MECKLENBURG COUNTY

Park and Recreation Department

MEMORANDUM

RE: Rezoning Petition #2022-133
PID# 02509144, 02509124

# RZ-1.0

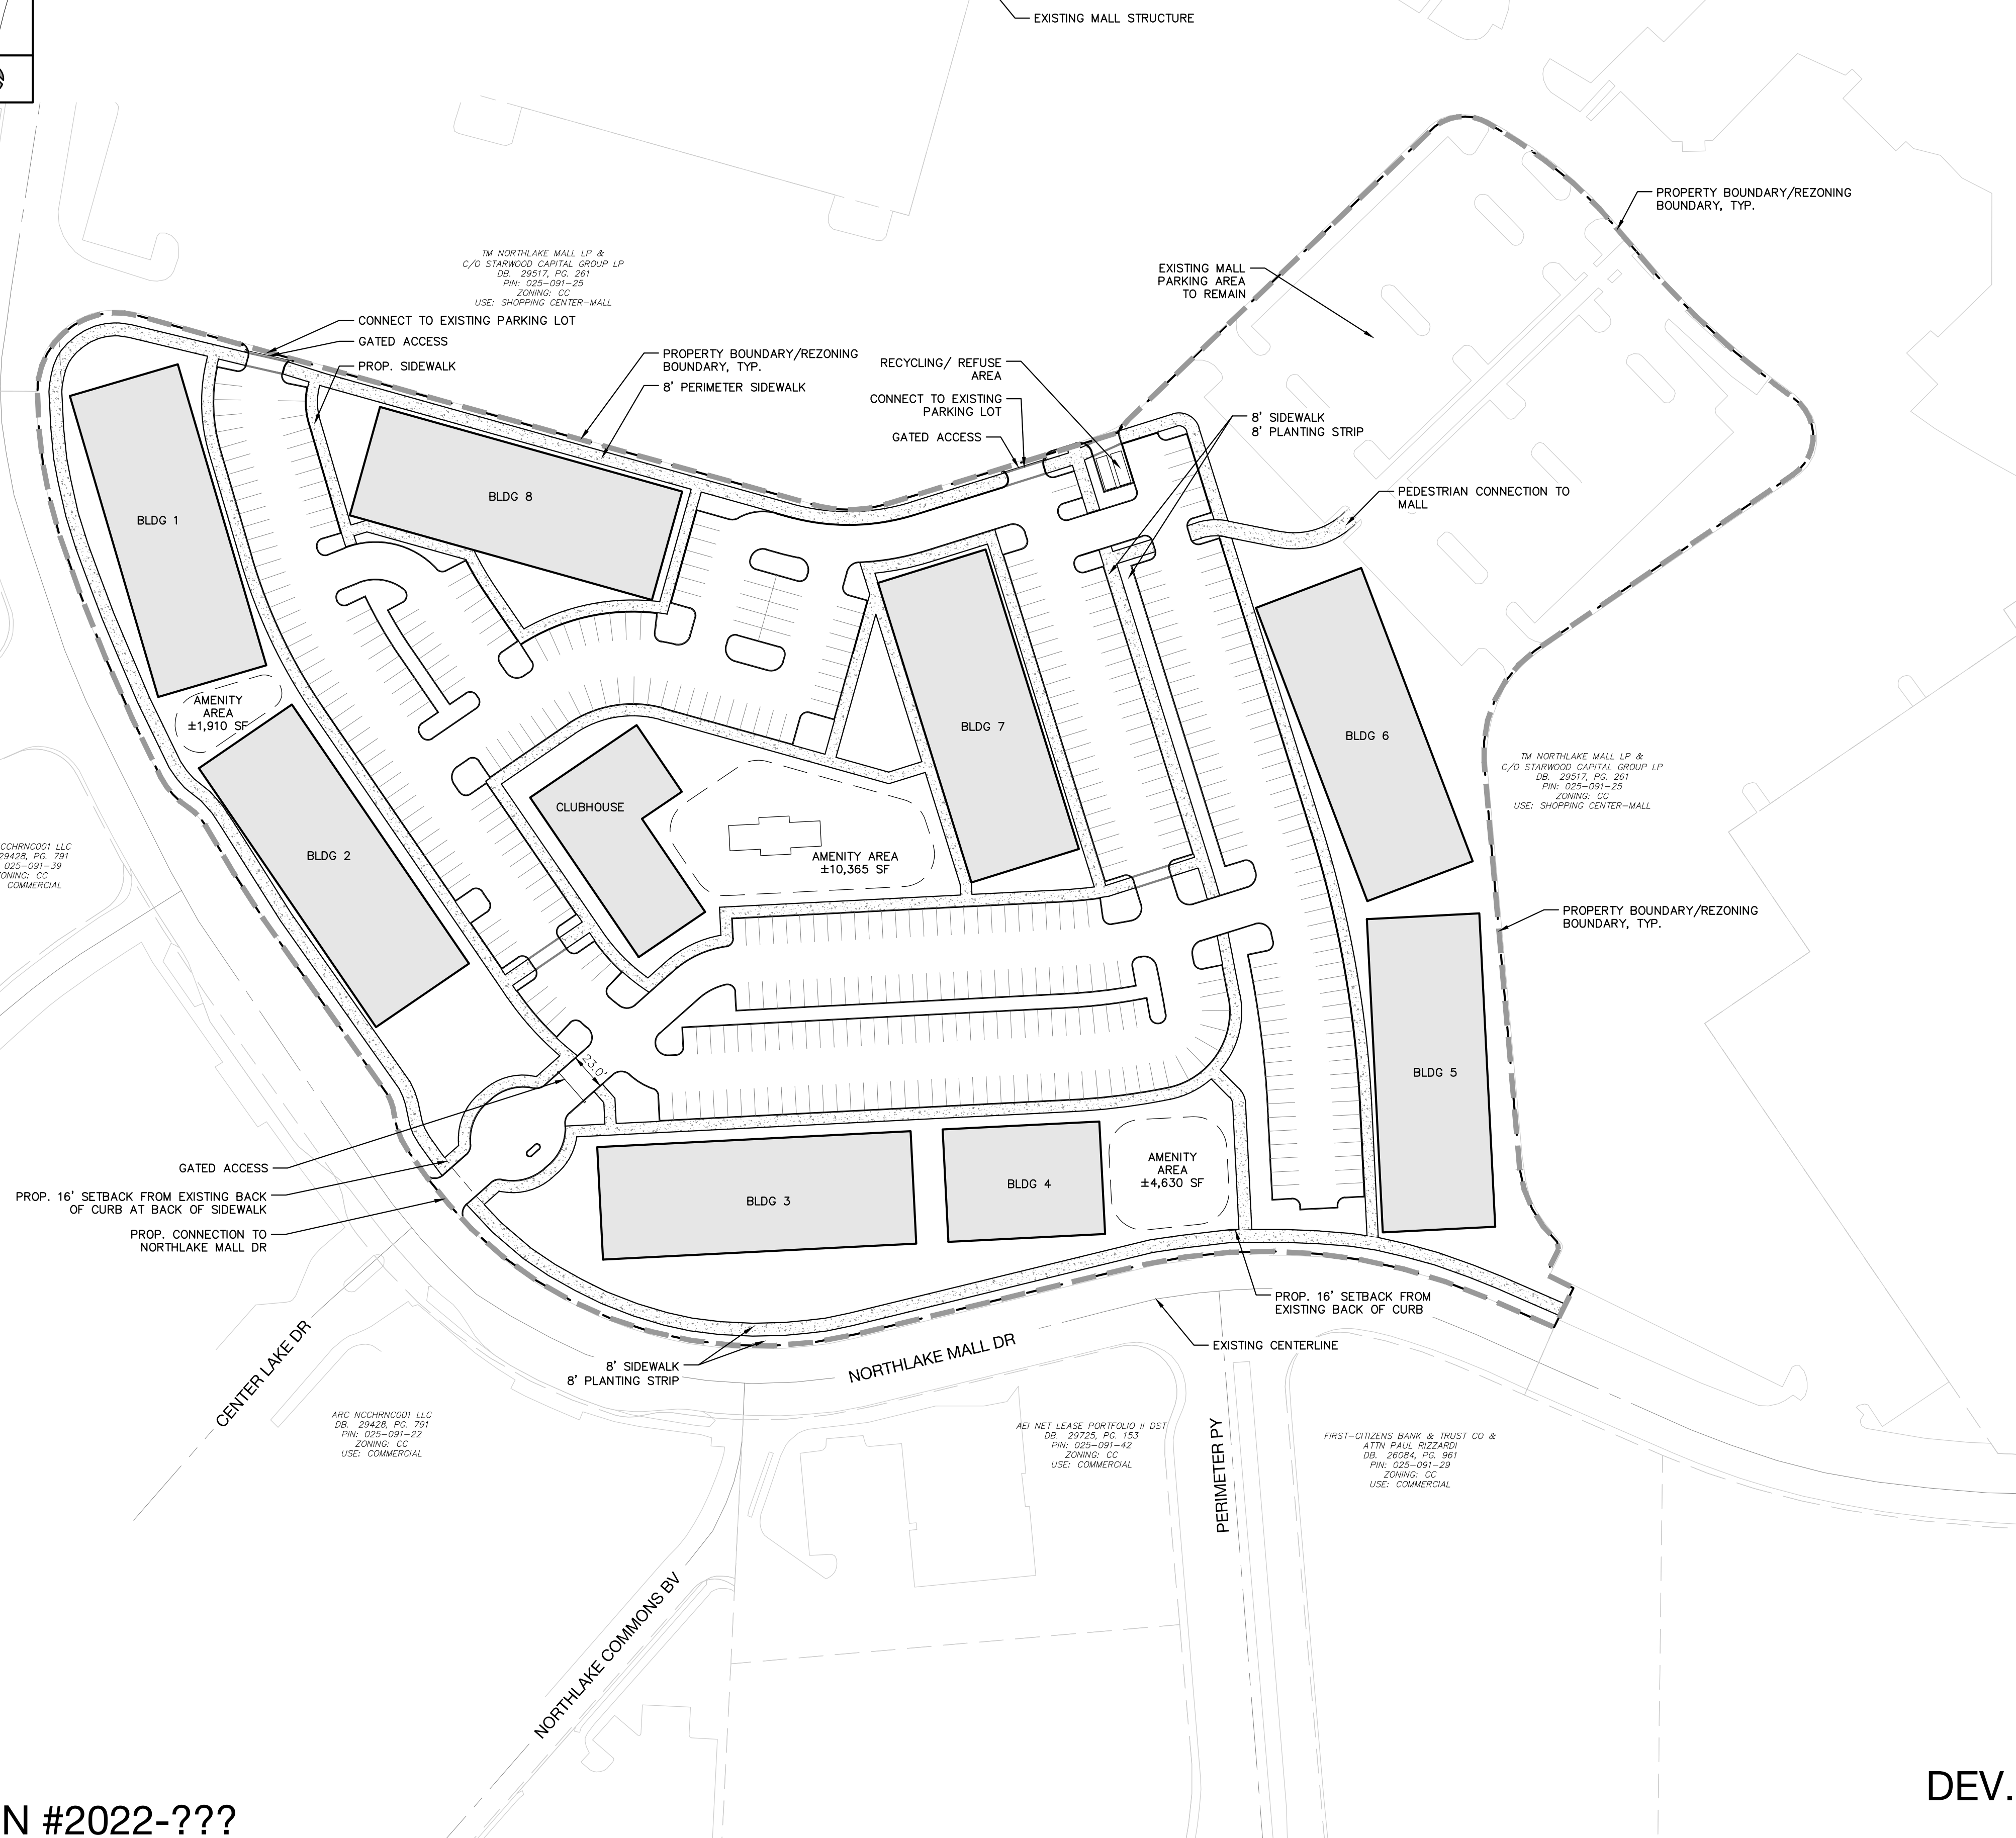
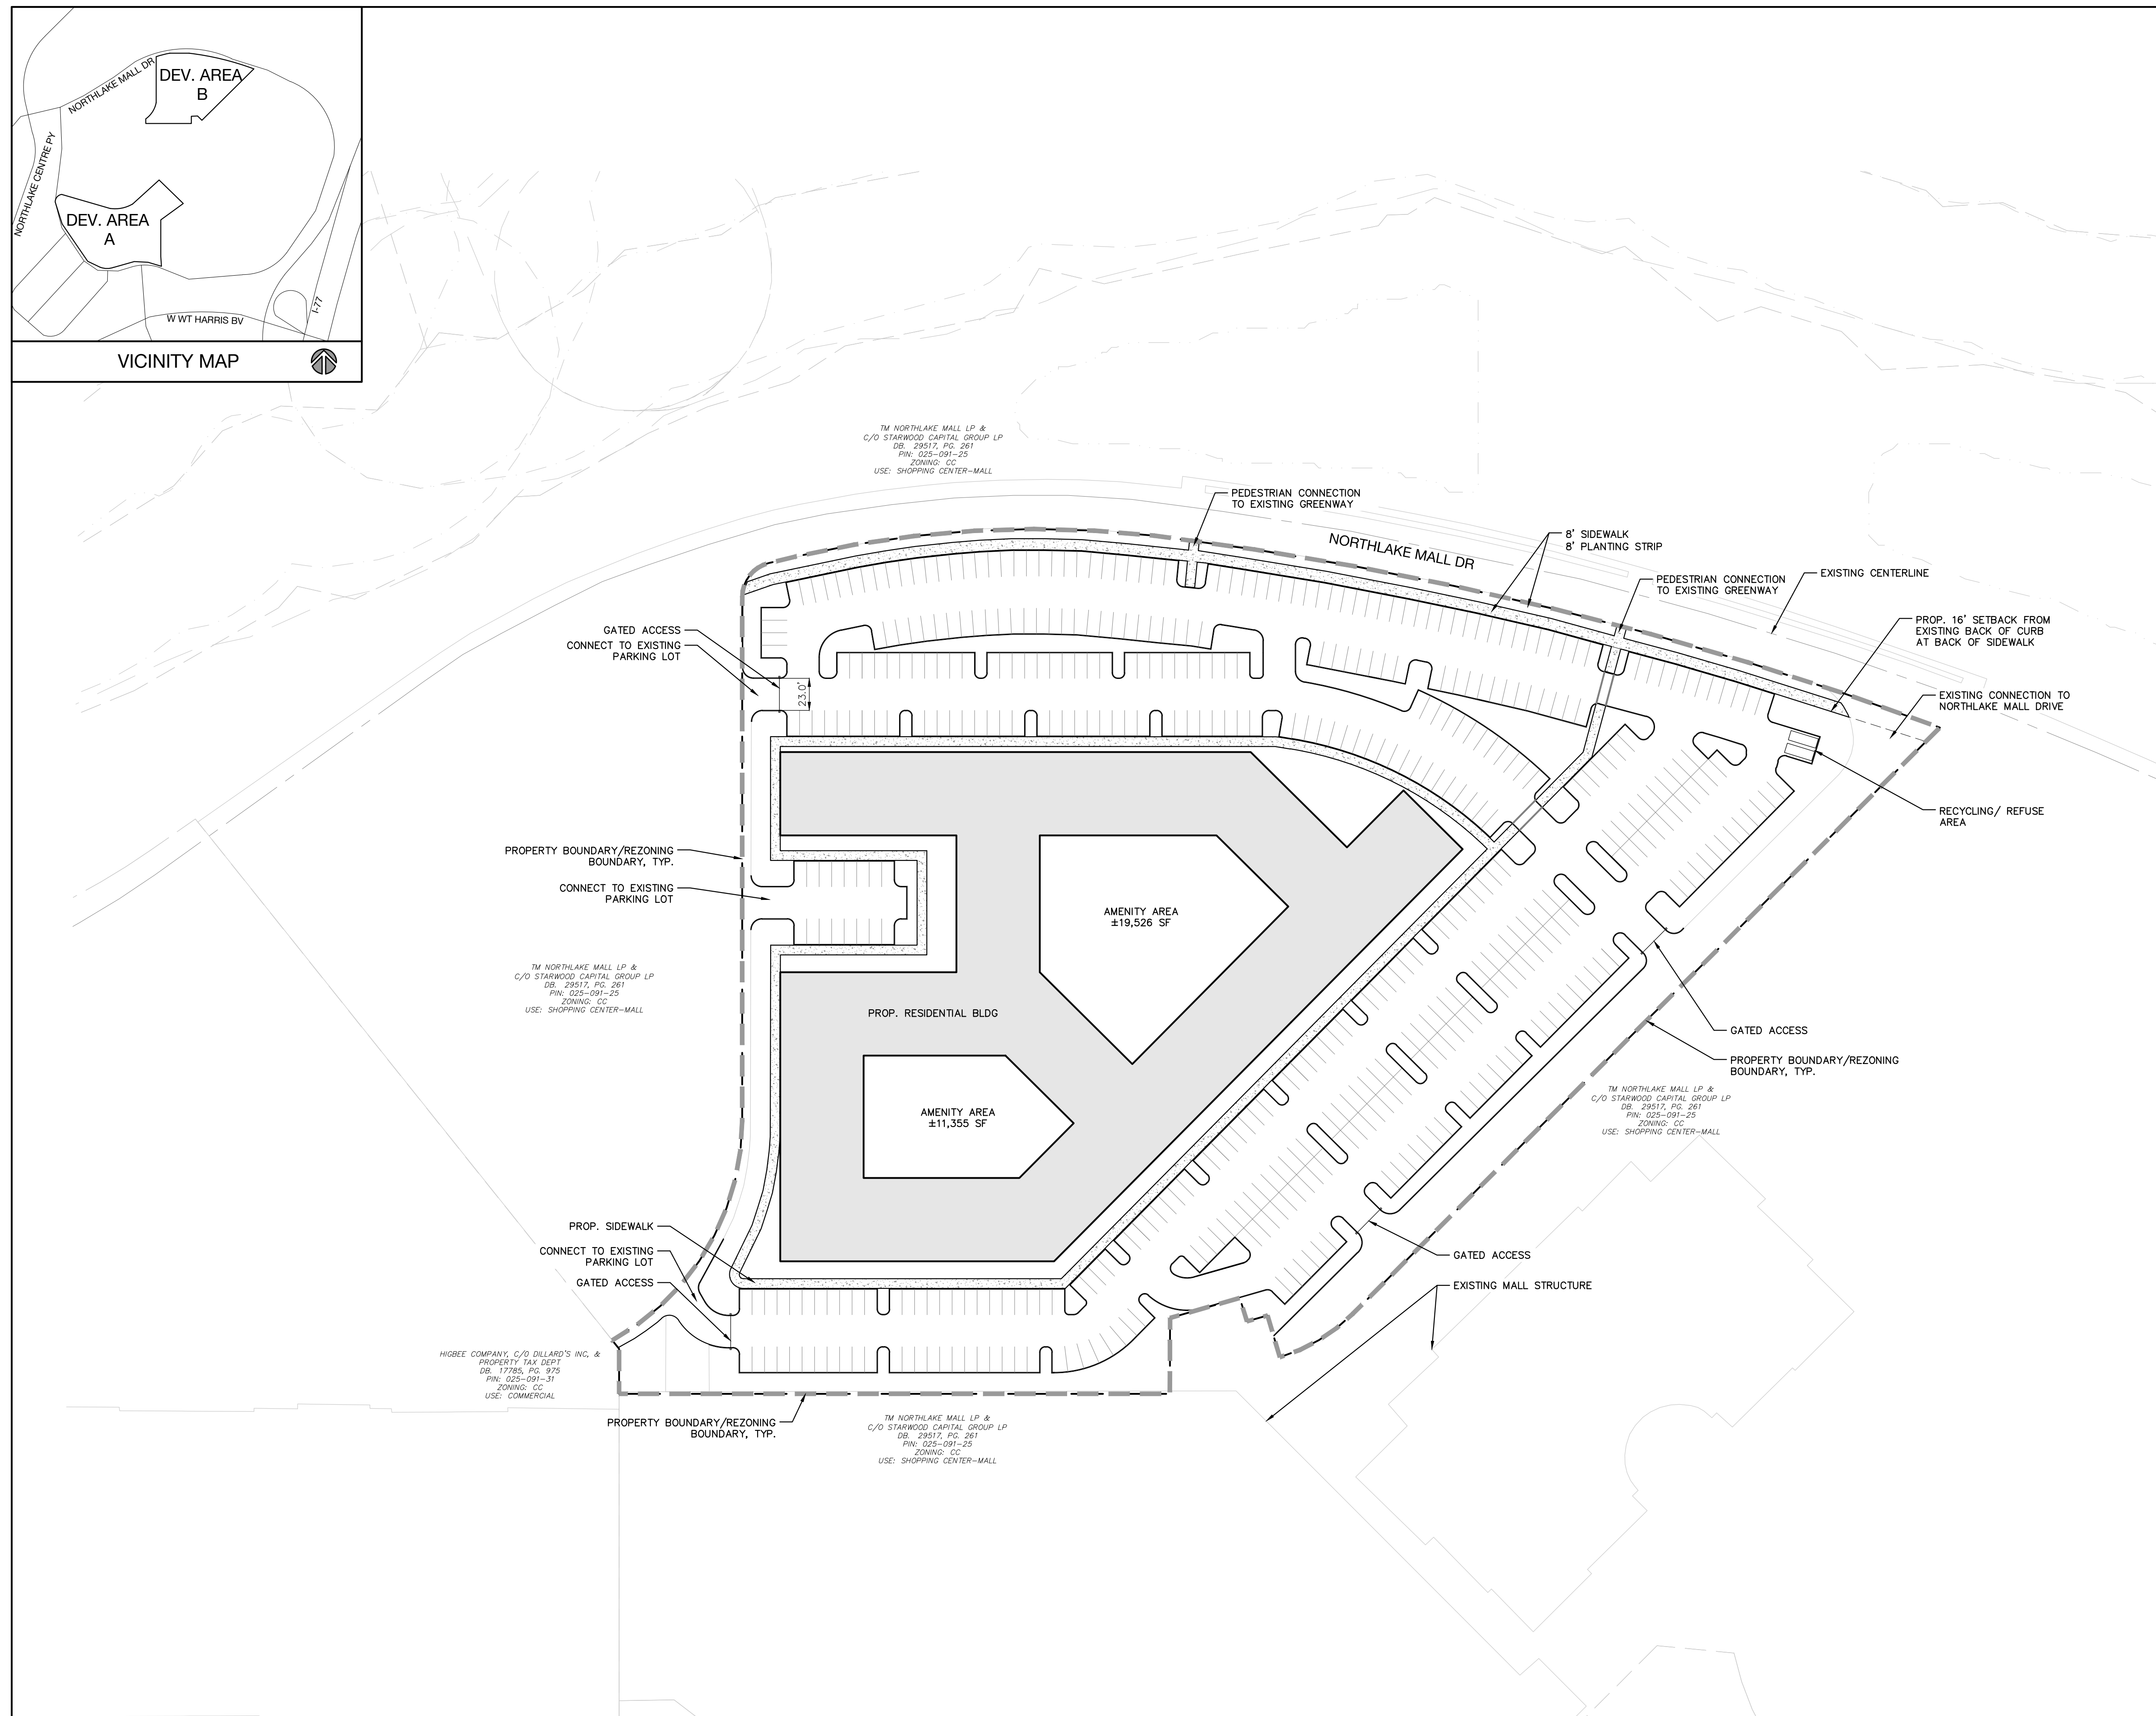
MCPR requests a minimum of 1.0 acre to be dedicated and conveyed to Mecklenburg County for a future local park. This requested park land shall be adjacent to a public right-of-way for access and is conducive for the development of the typical amenities found in a neighborhood park and cannot include tree save parcels or storm water BMP's.
